From: Jessica Riches <Jessica.Riches@arun.gov.uk>
Sent: 19 July 2022 14:47
To: Planning.Responses <Planning.Responses@arun.gov.uk>
Subject: FW: A/91/22/DOC Land North of Water Lane, Angmering

A/91/22/DOC

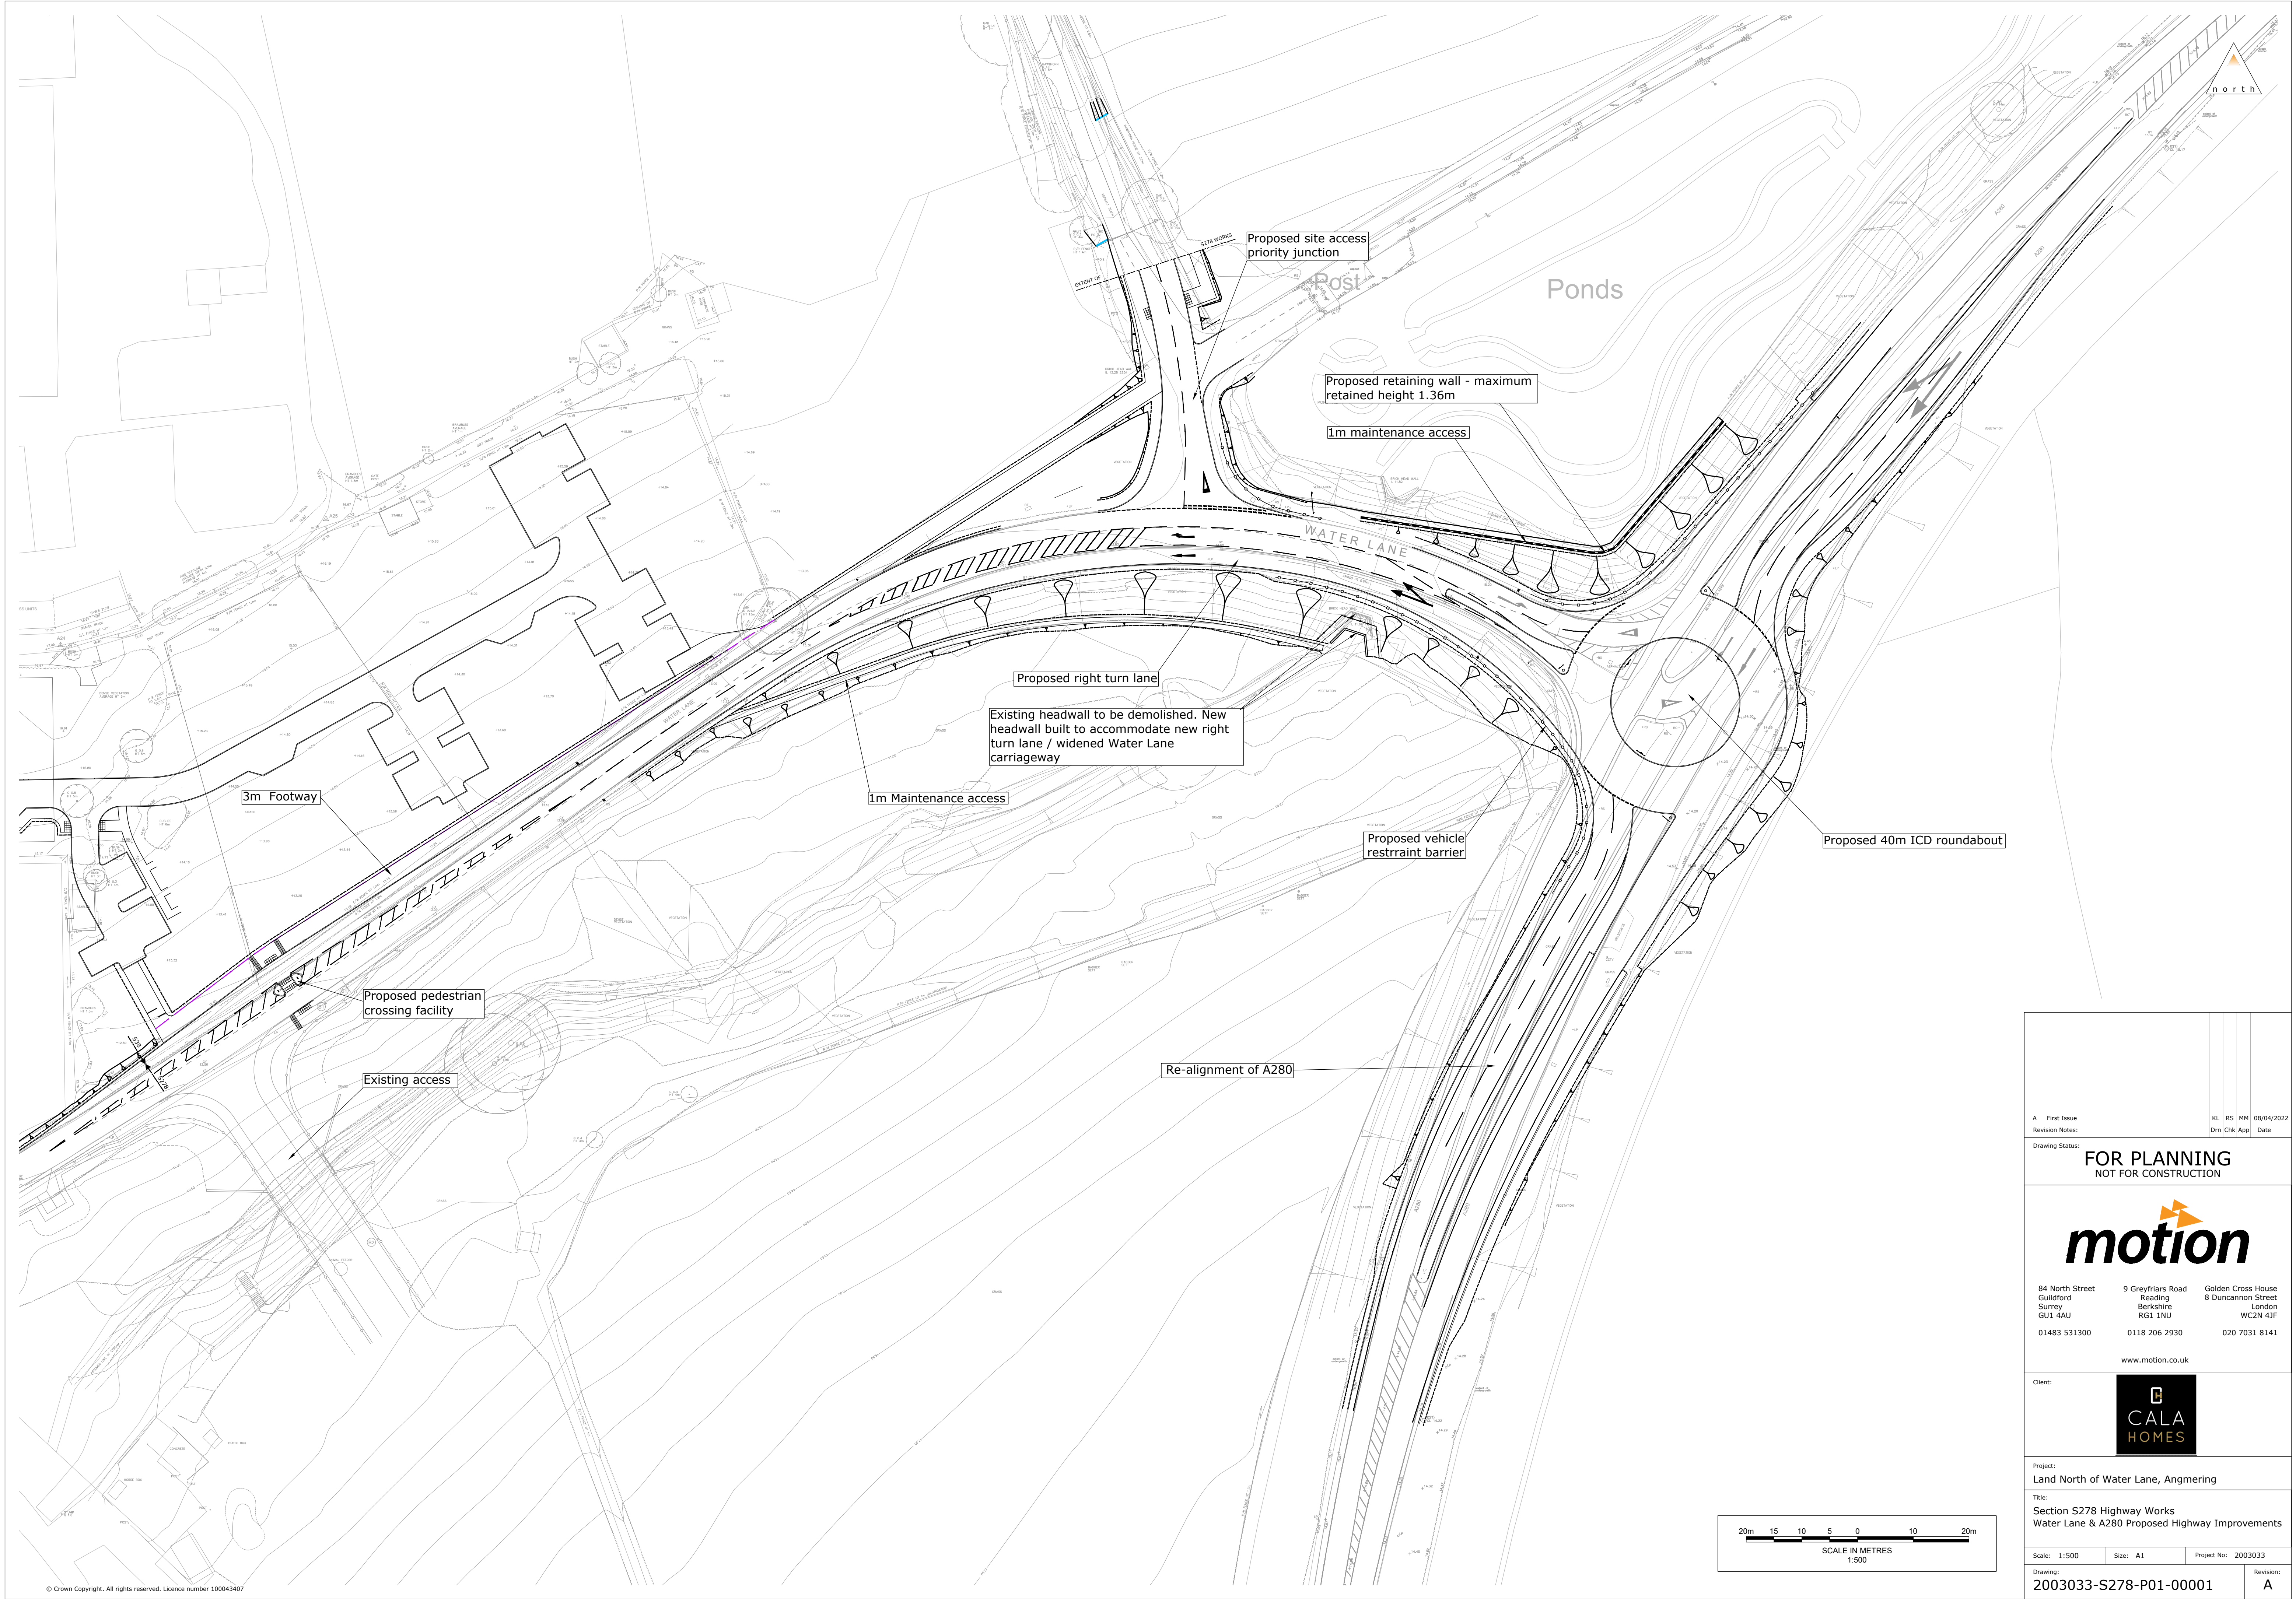
The plans submitted show a 3m wide footway along Water Lane and should be noted as a shared use route

Ped /Cycle link into Dappers Lane shows a staggered barrier where as im pretty sure we agreed guardrailing along Water Lane to stop peds/cycles going into the carriageway. This would then allow the route to be used by a wide variety of cycles.

As such the plans should be updated.
